Please ask for: Ms Iqraa Malik
Email: iqraa.malik@terraquest.co.uk
Telephone: 0121 234 1390
Our Ref: M/20/25/HH
Your Ref:
Date: 17th February 2025

Application for Planning Permission for Works or Extension to a Dwelling

Development: Conversion of detached garage and store with single storey link extension.
Location: 3 Tuscan Avenue Middleton On Sea PO22 7TD

LOCATION PLAN
1:1250

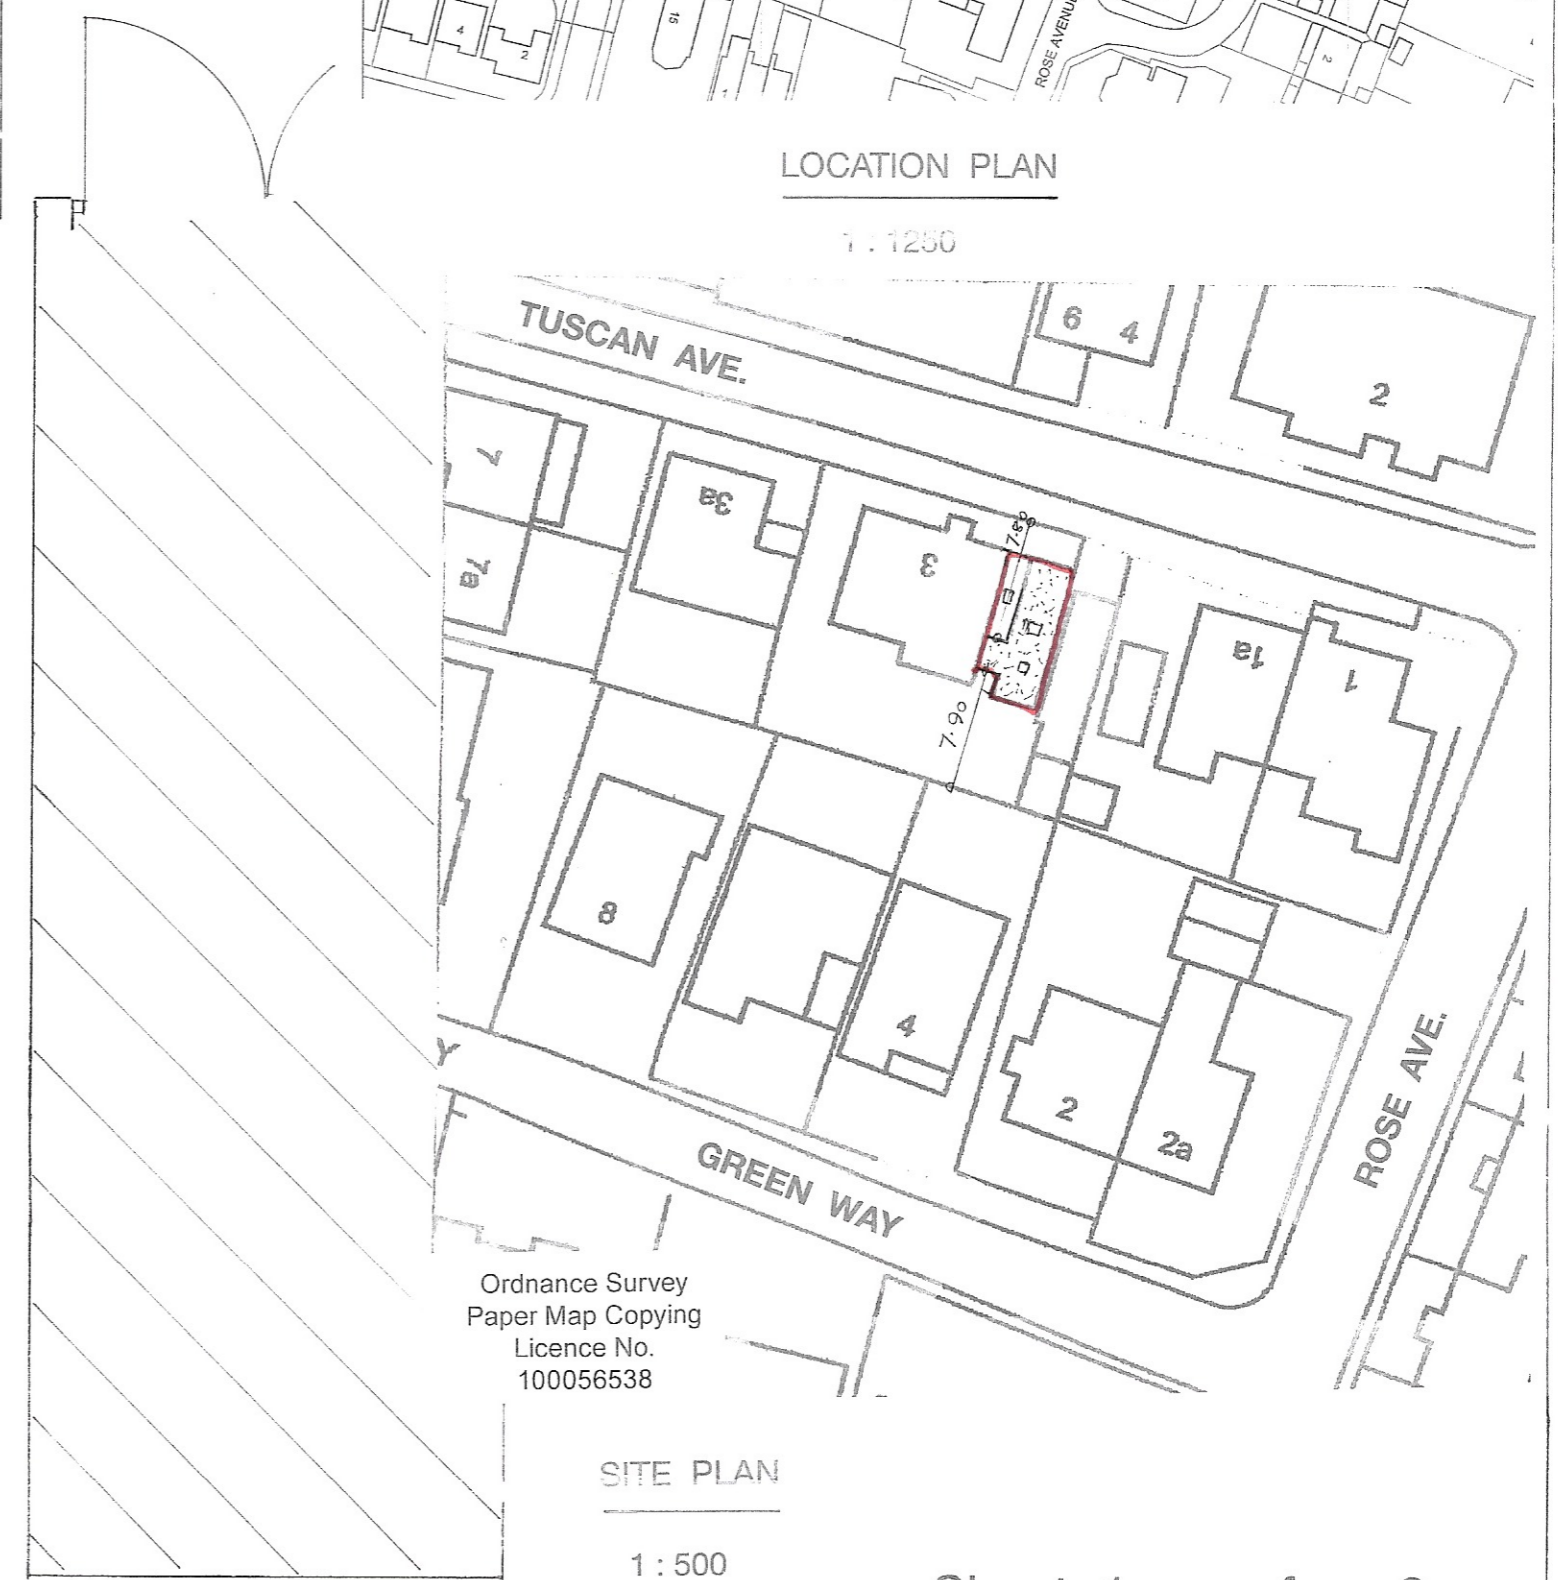
Please confirm whether the street is a private road, if so, you are required to amend the location plan red outline to include access to the site from a public highway. Further details of what must be included on the plan can be found in the Validation Requirements List.

NORTH

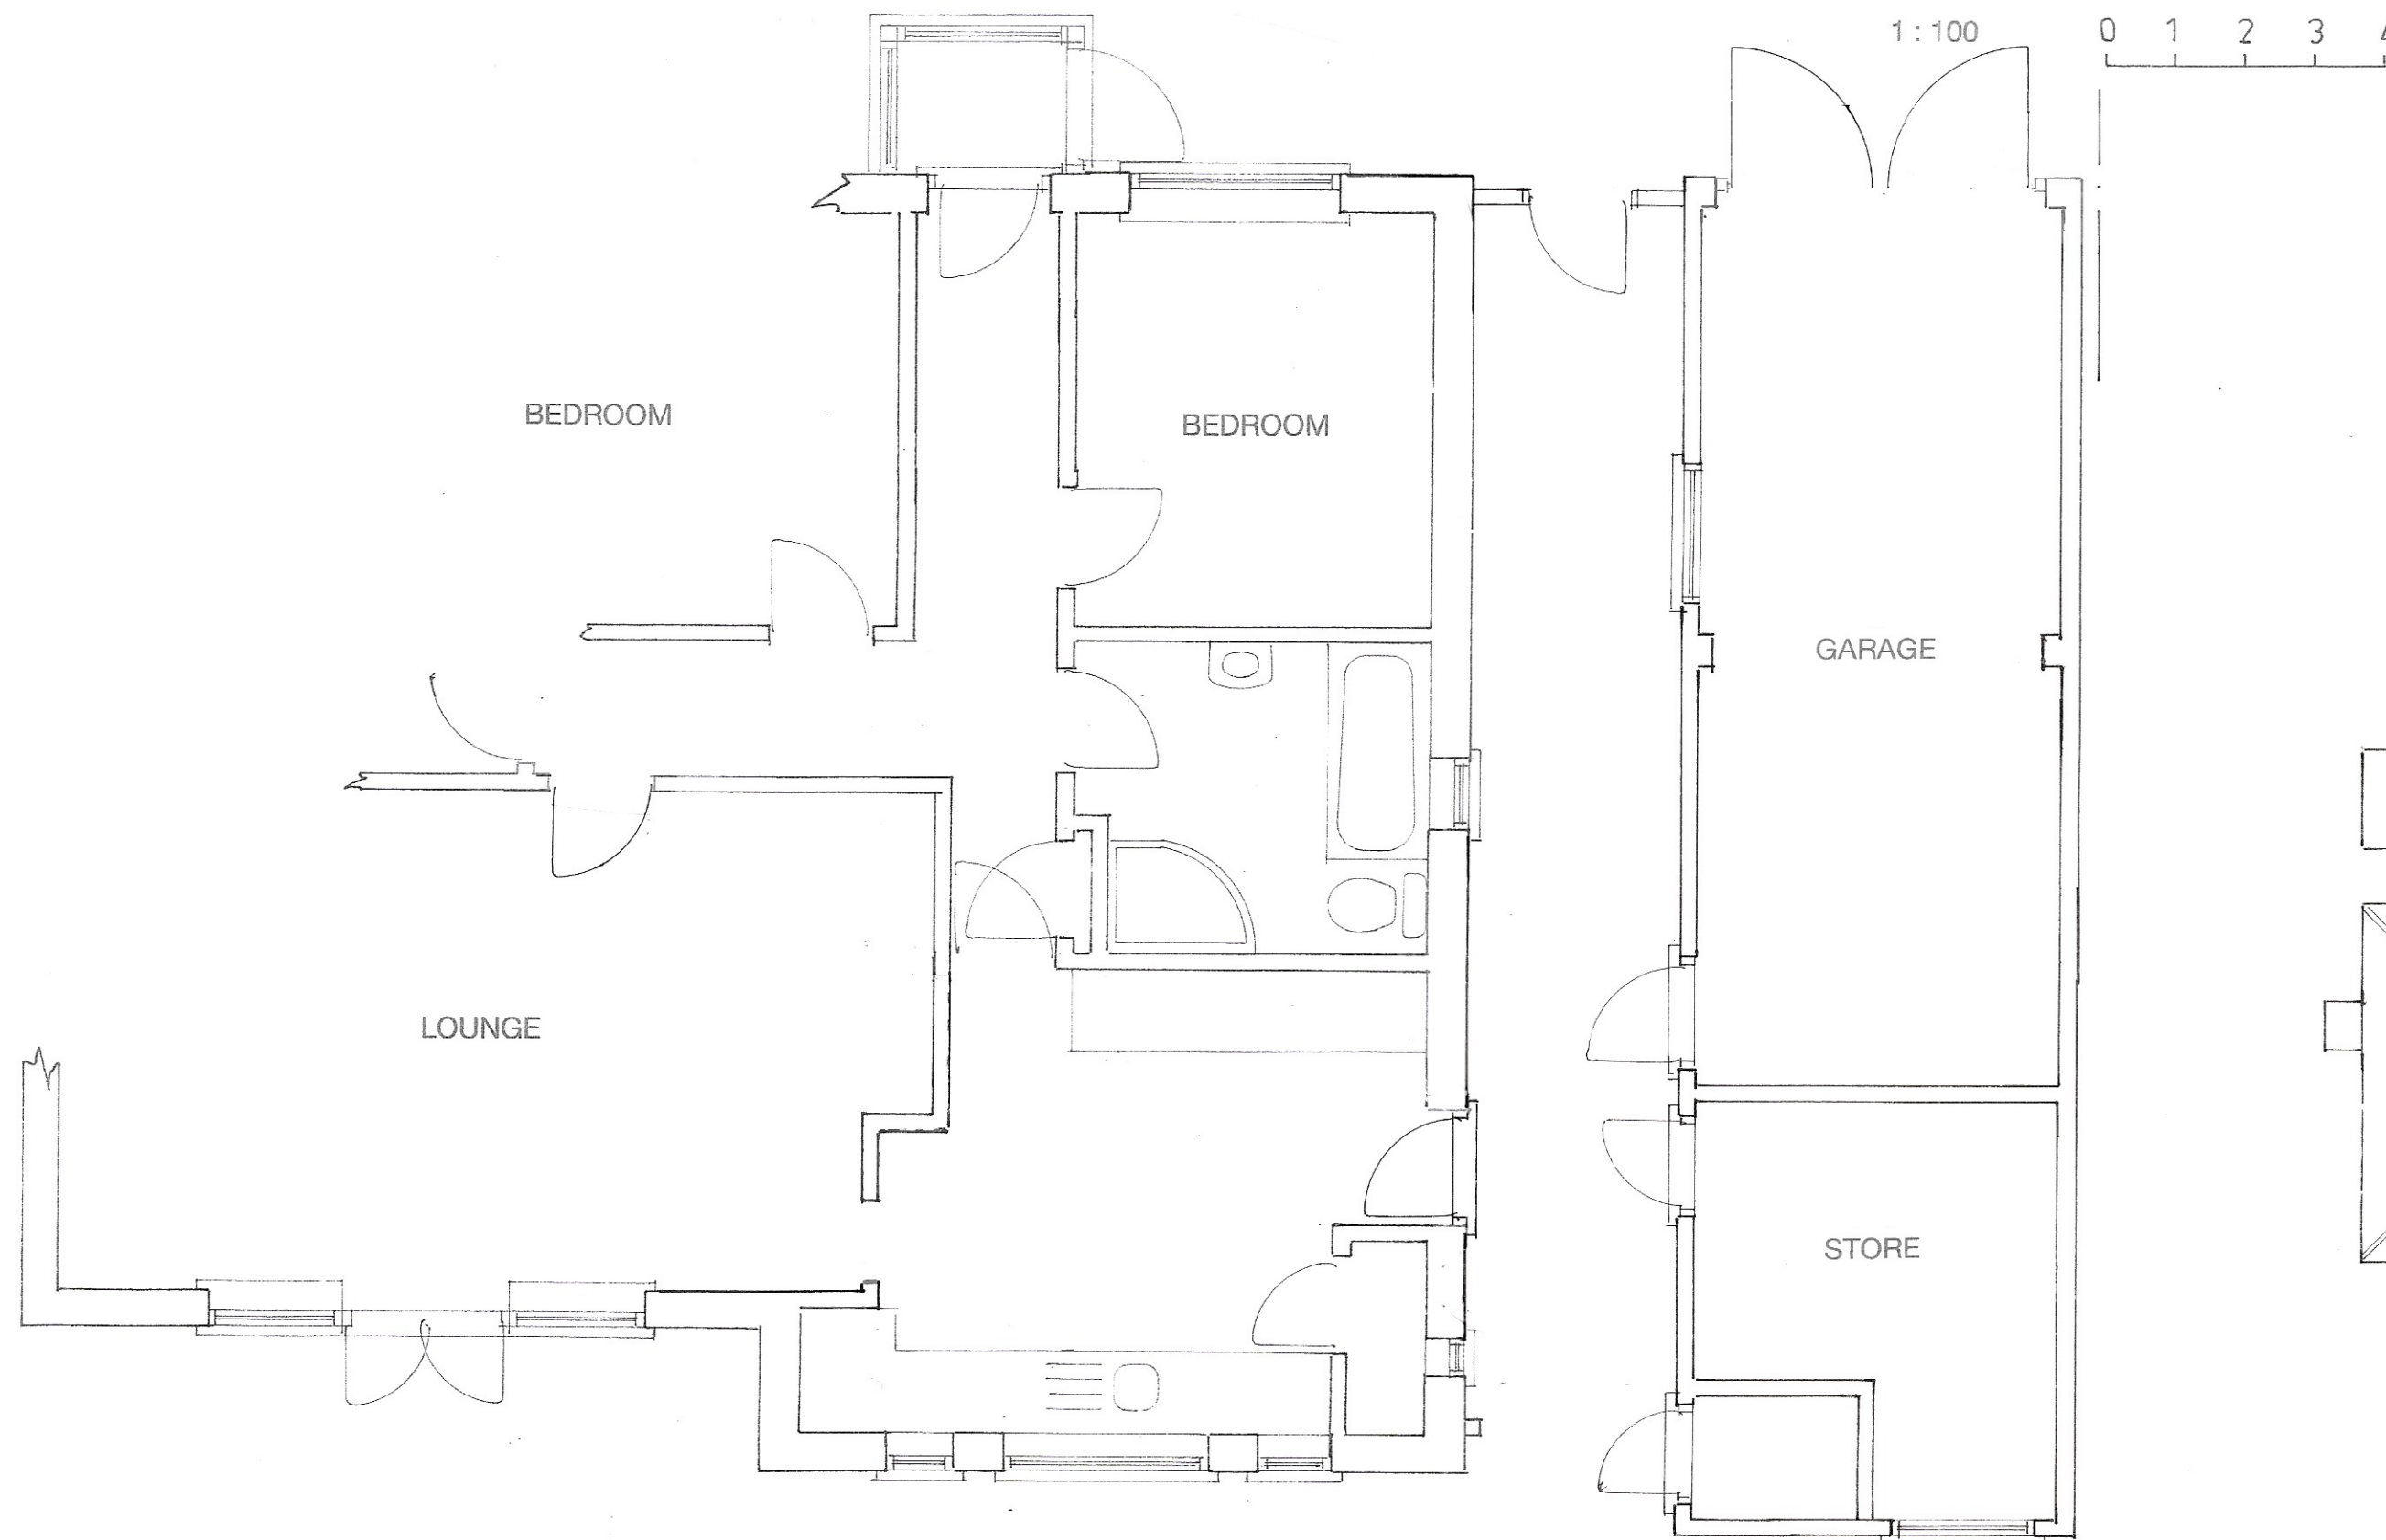
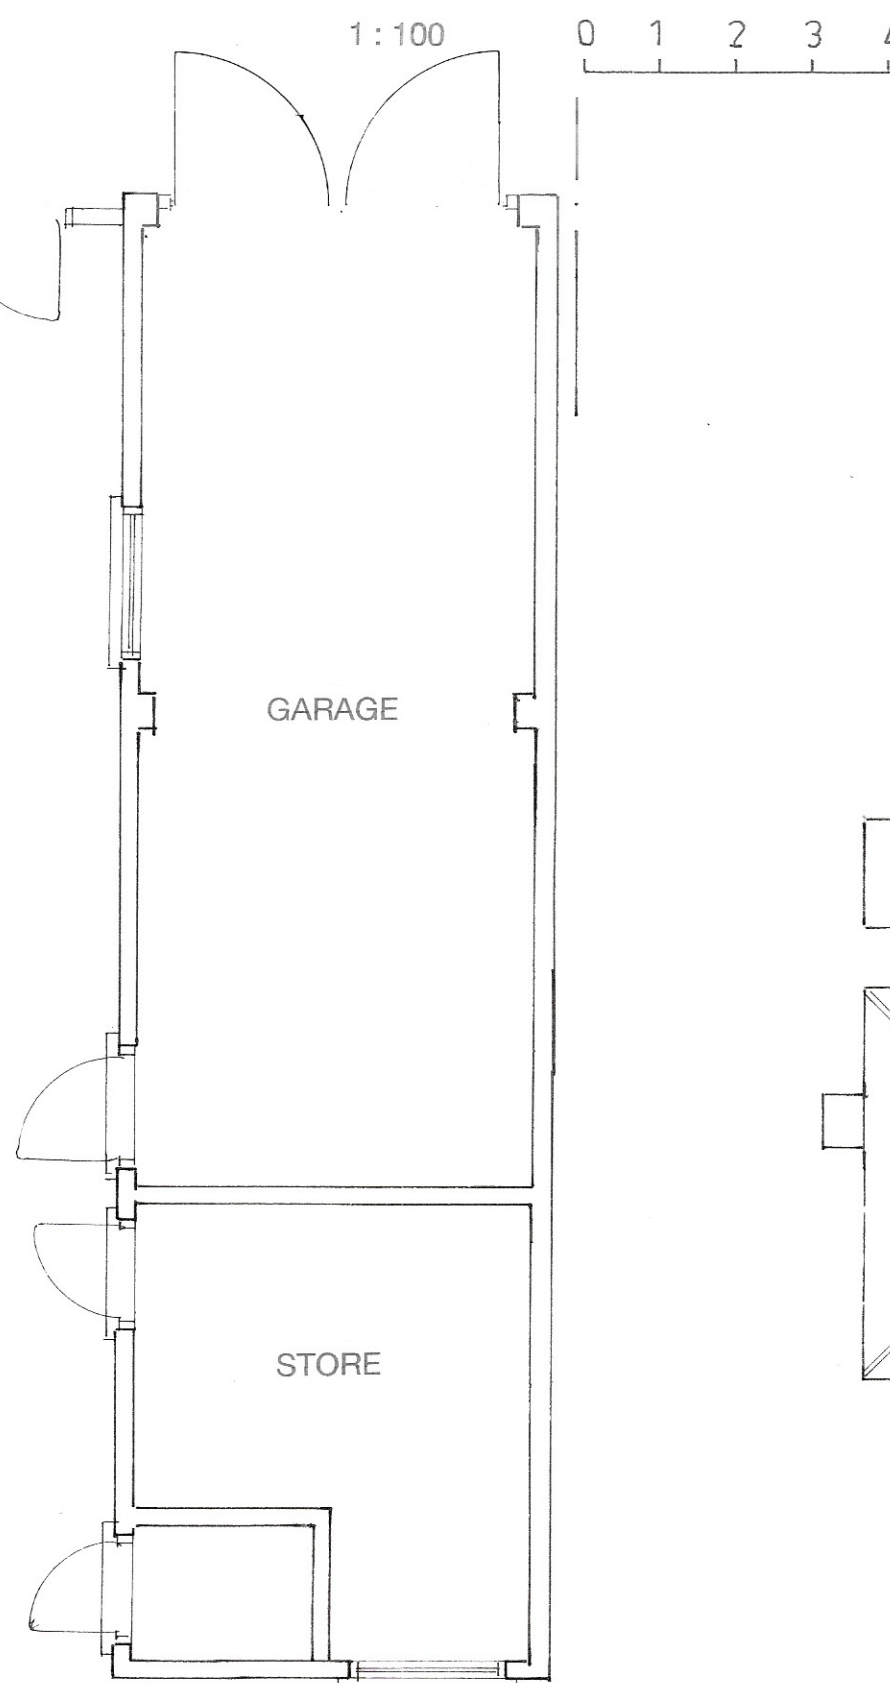
The existing floor plan shows a door which is missing from the existing north elevation, please review and amend.
